Recommendation Report for Planning Permission for Works or Extension to a Dwelling

REF NO: K/29/15/HH

LOCATION: The Tower
Seaview Avenue
Kingston

PROPOSAL: Two storey extension to East, first floor extension to West & new pitched roof on existing garage (resubmission following K/20/15/HH).

Drawing Name
Proposed Elevations

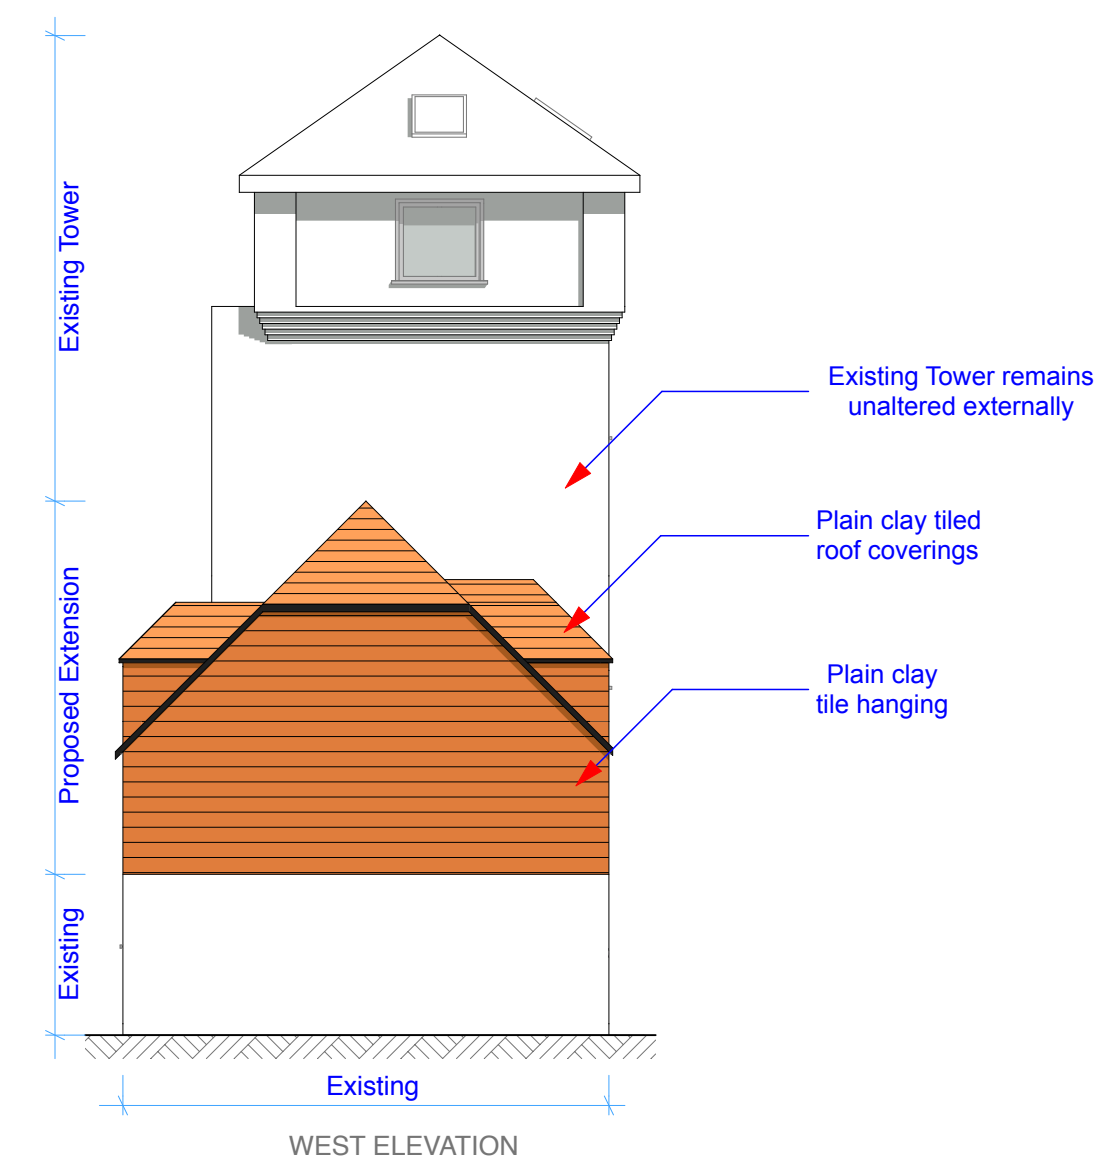
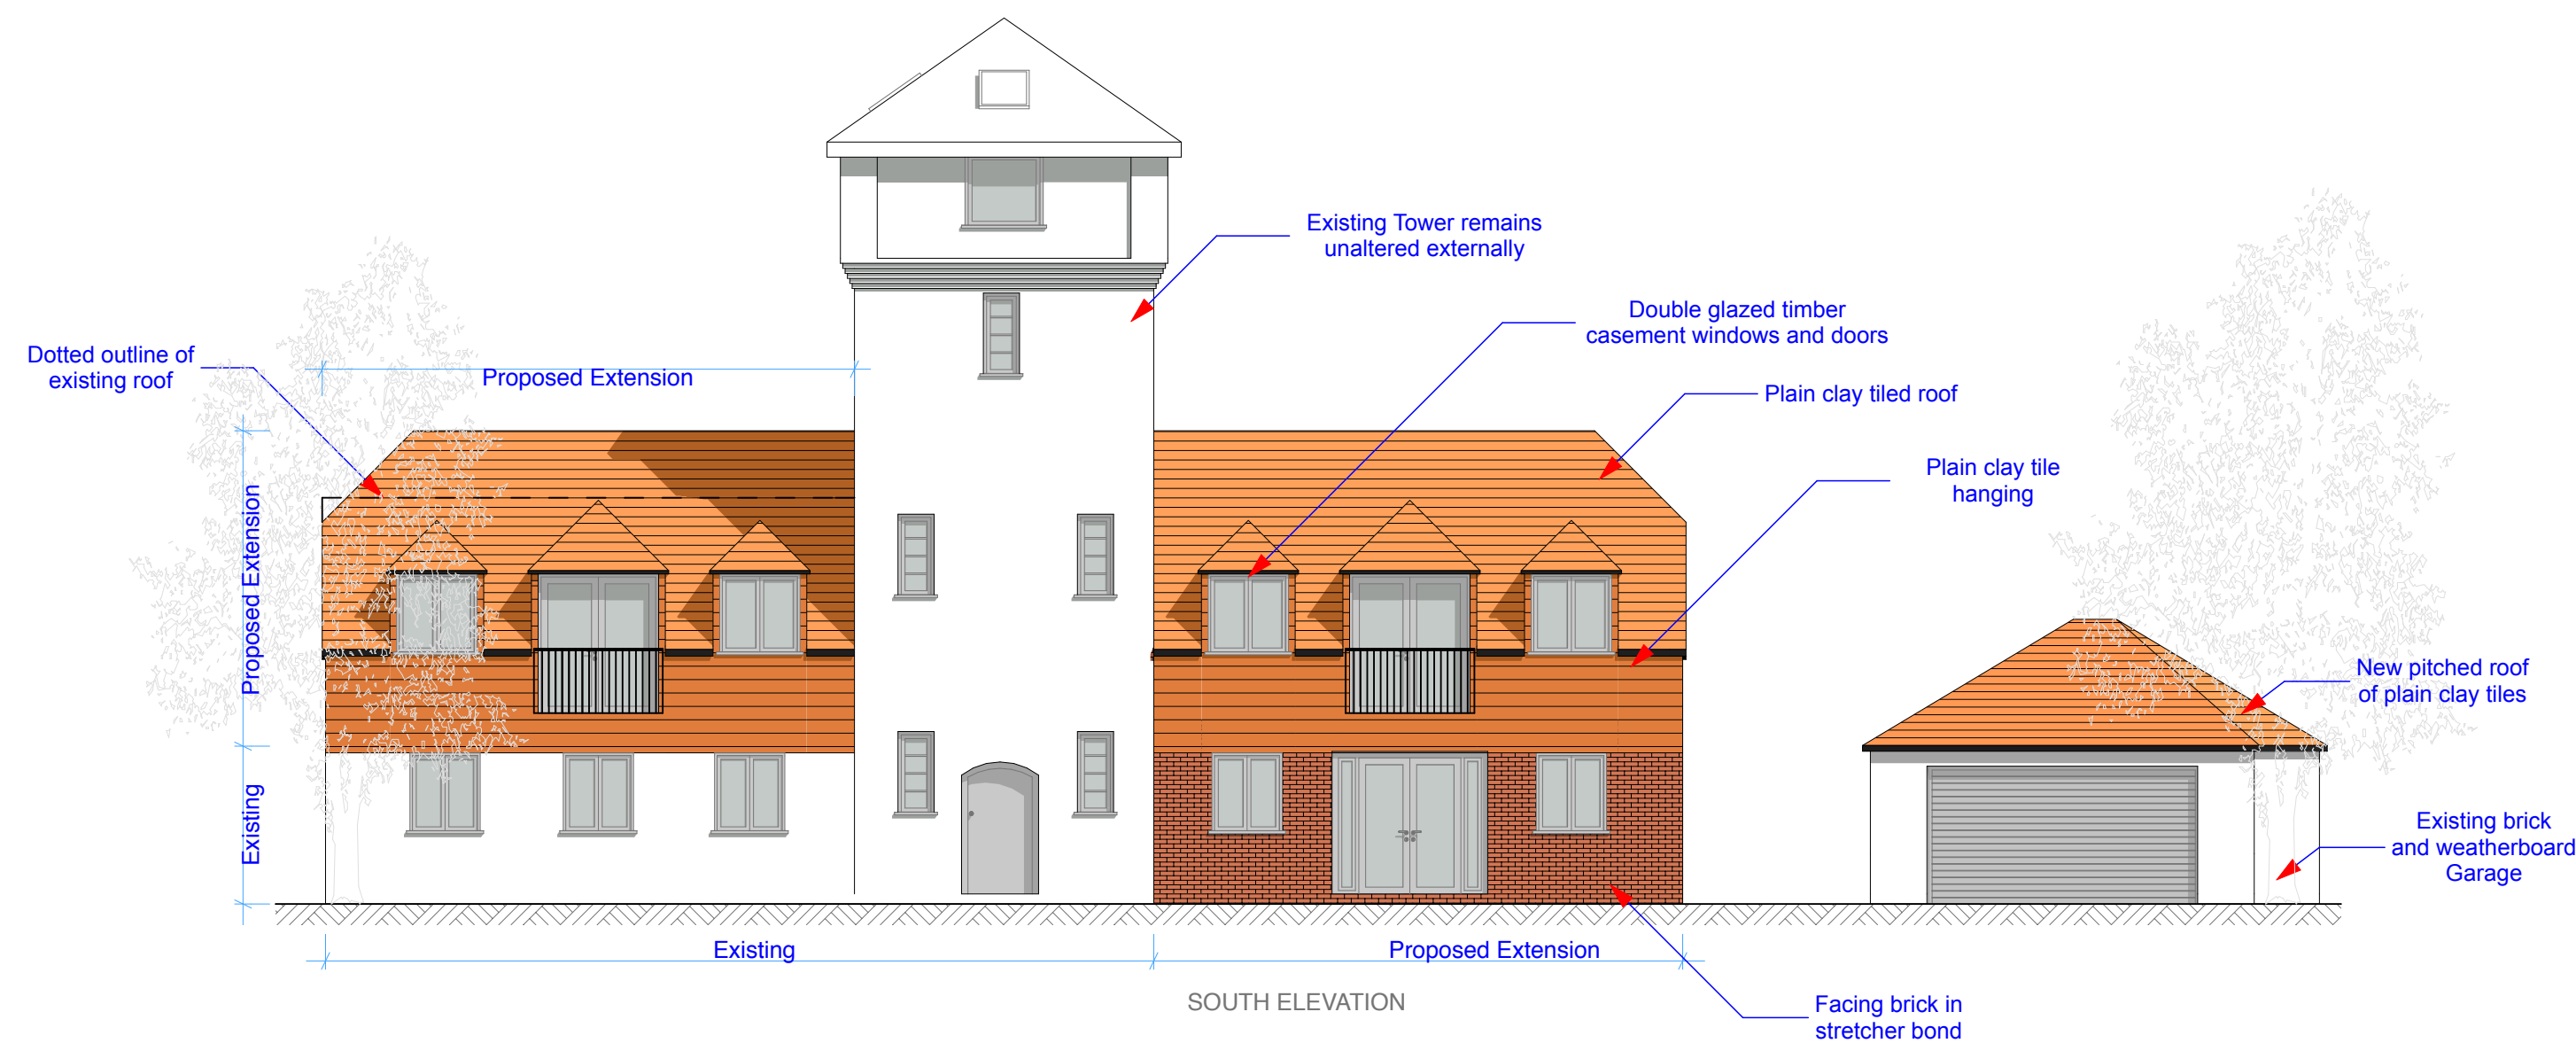
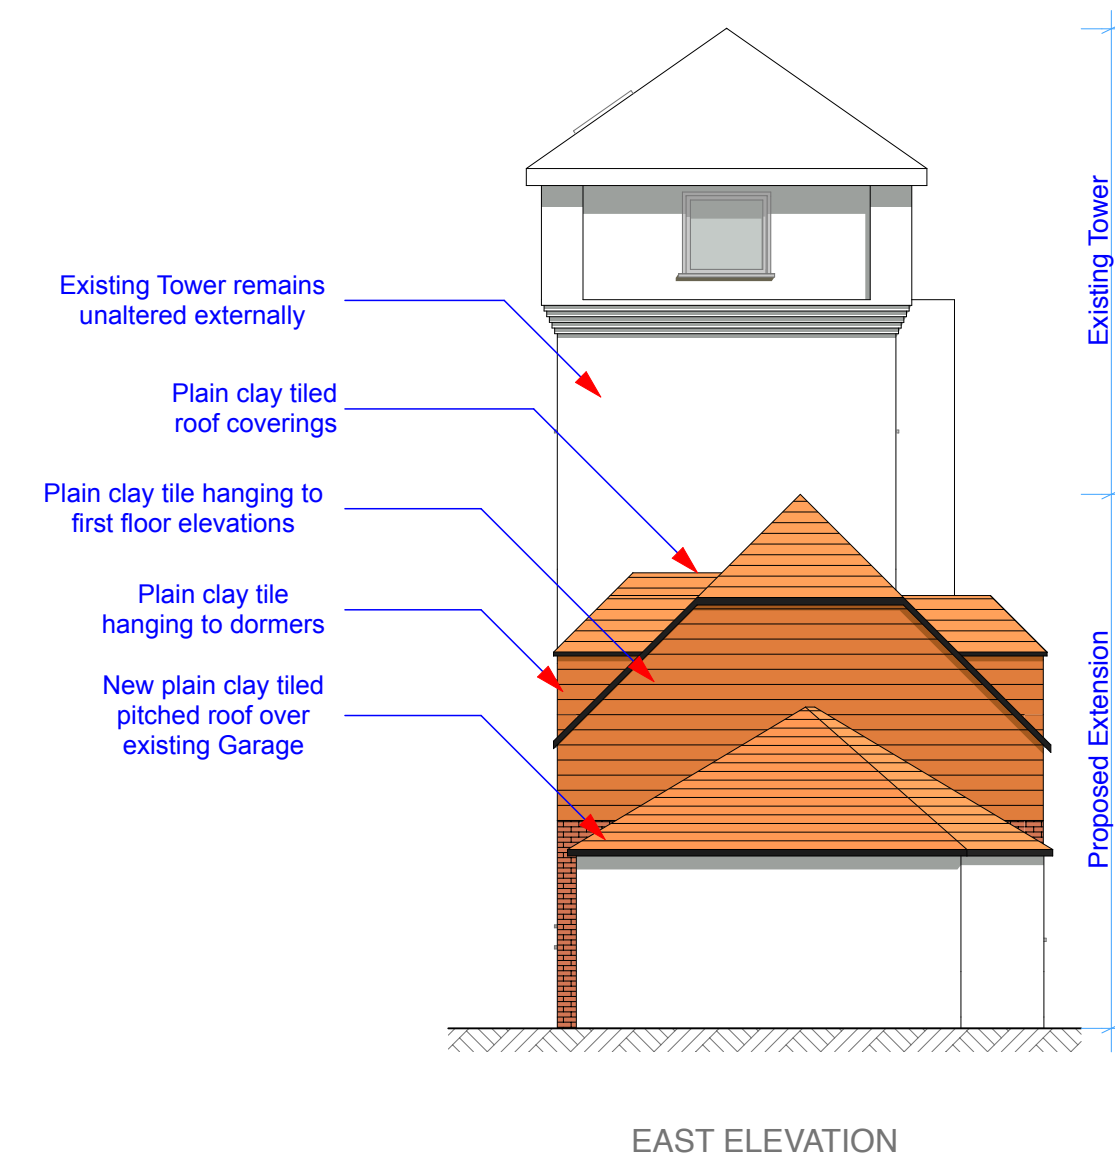
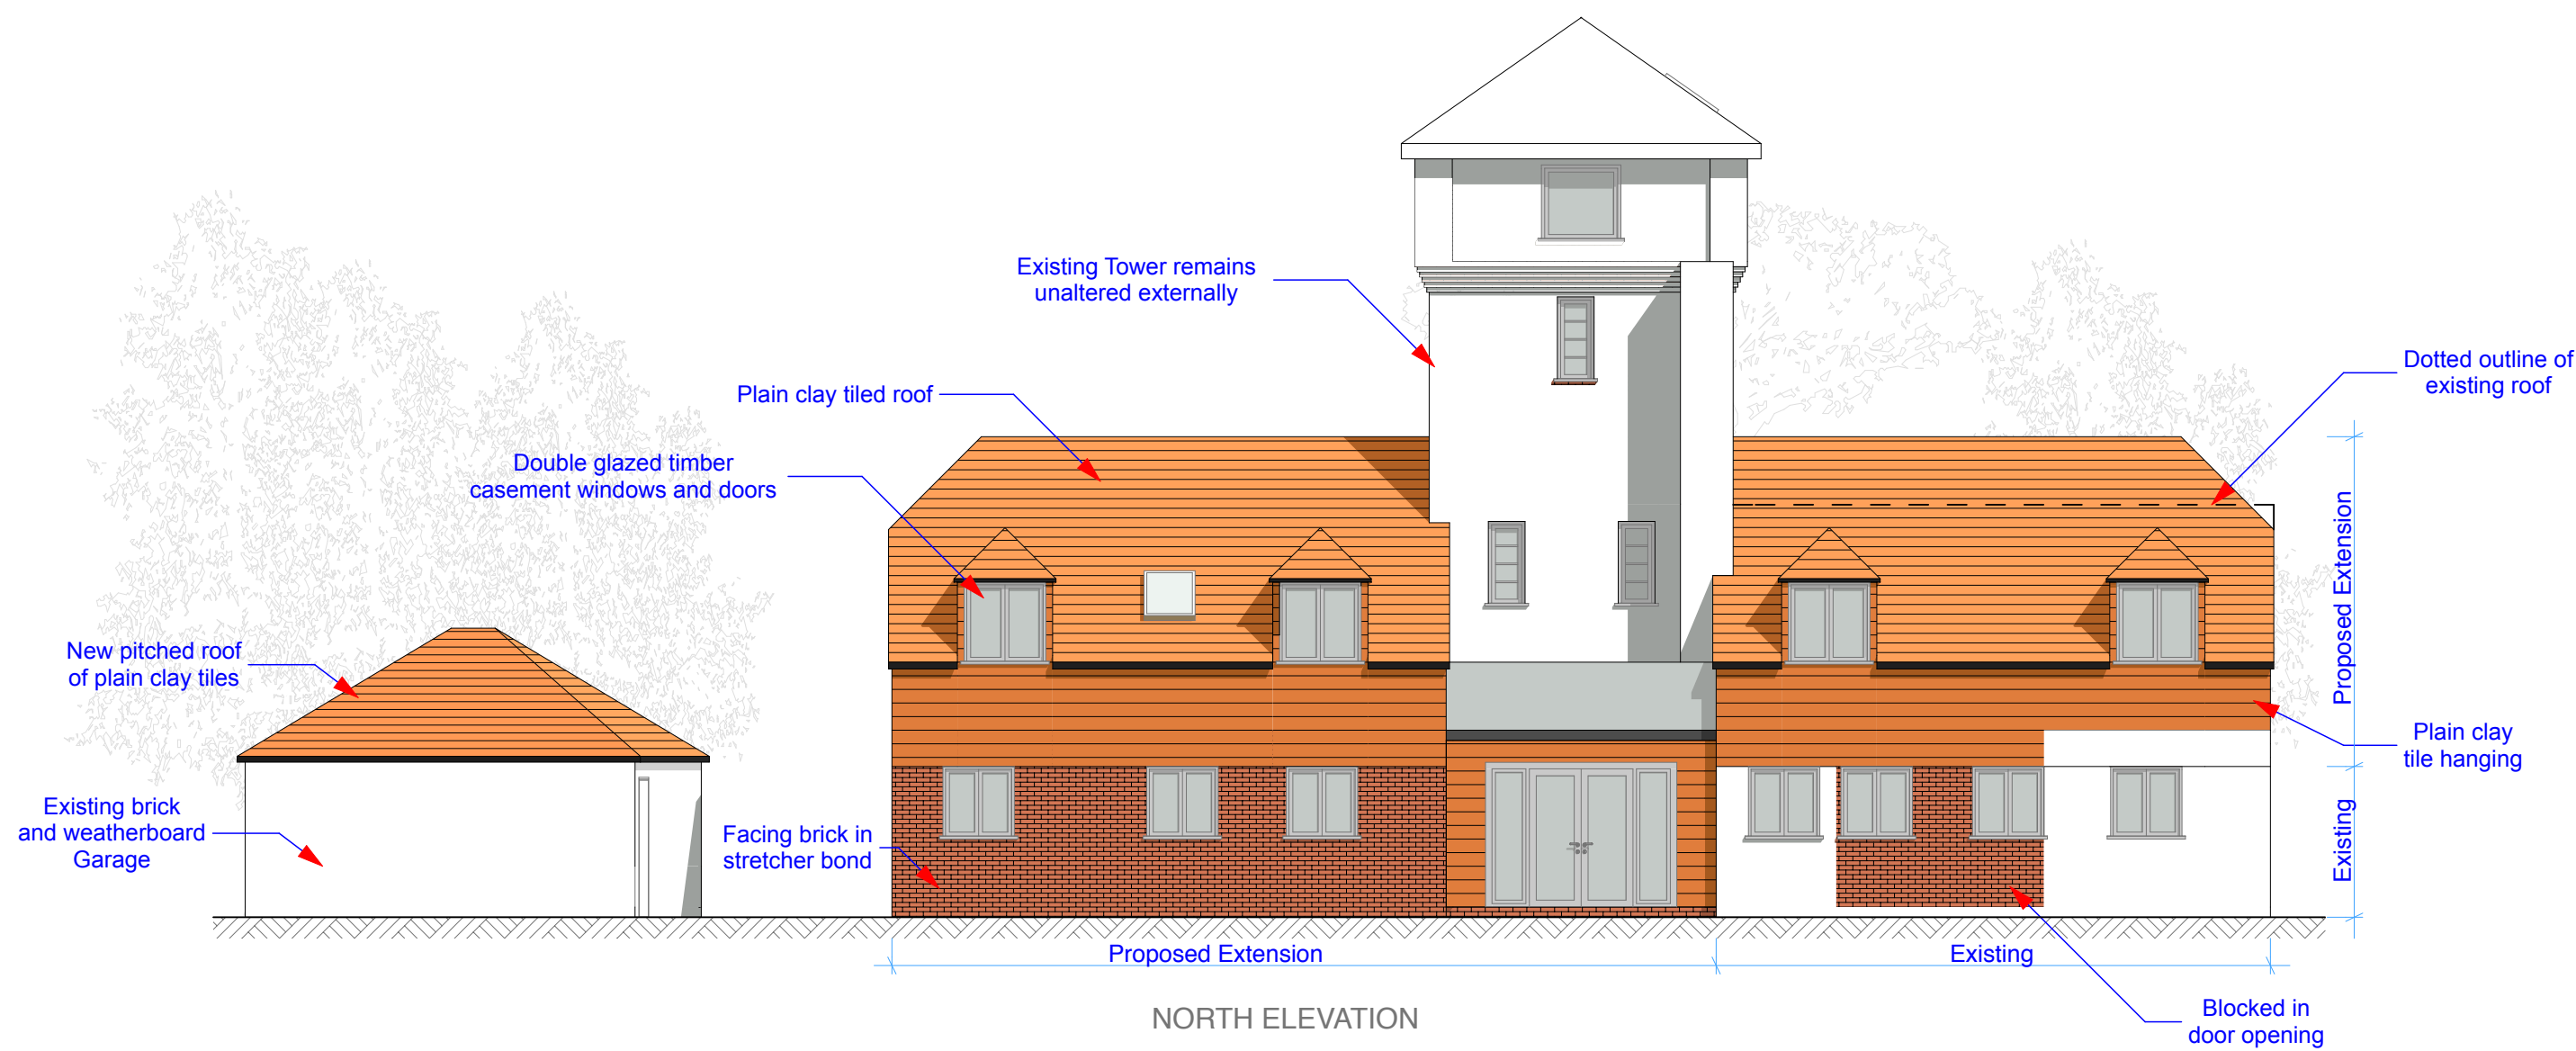
However, there is still some concern with regards to the roof structure and the impact that the dormers/windows will have upon the property. Essentially, if not careful, they have the power to become quite a dominant feature (especially the southern elevation). In addition, the use of the clay tile as part of the wall gives the impression that the roof extends down much further than it actually does. There is no easy solution to this issue, but may require some thought.

The fenestration should be designed so that it complements the property.

The proposal will feature 10 No. dormers, with 6 located on the primary elevation and 4 to the rear. The existing dwelling features two dormers on the primary elevation of the property currently with roof lights in the rear elevation. Although the number of dormers present upon the property has increased they are not considered to be an overly dominant feature on the site. They are

designed sympathetically in both size and appearance and as such are considered acceptable.

Details of materials, finishes and fenestration should be provided by way of condition.

- 4 No development shall be carried out until details of the proposed window construction and fenestration details have been submitted to and approved by the Local Planning Authority and the window so approved shall be in accordance with these approved details.
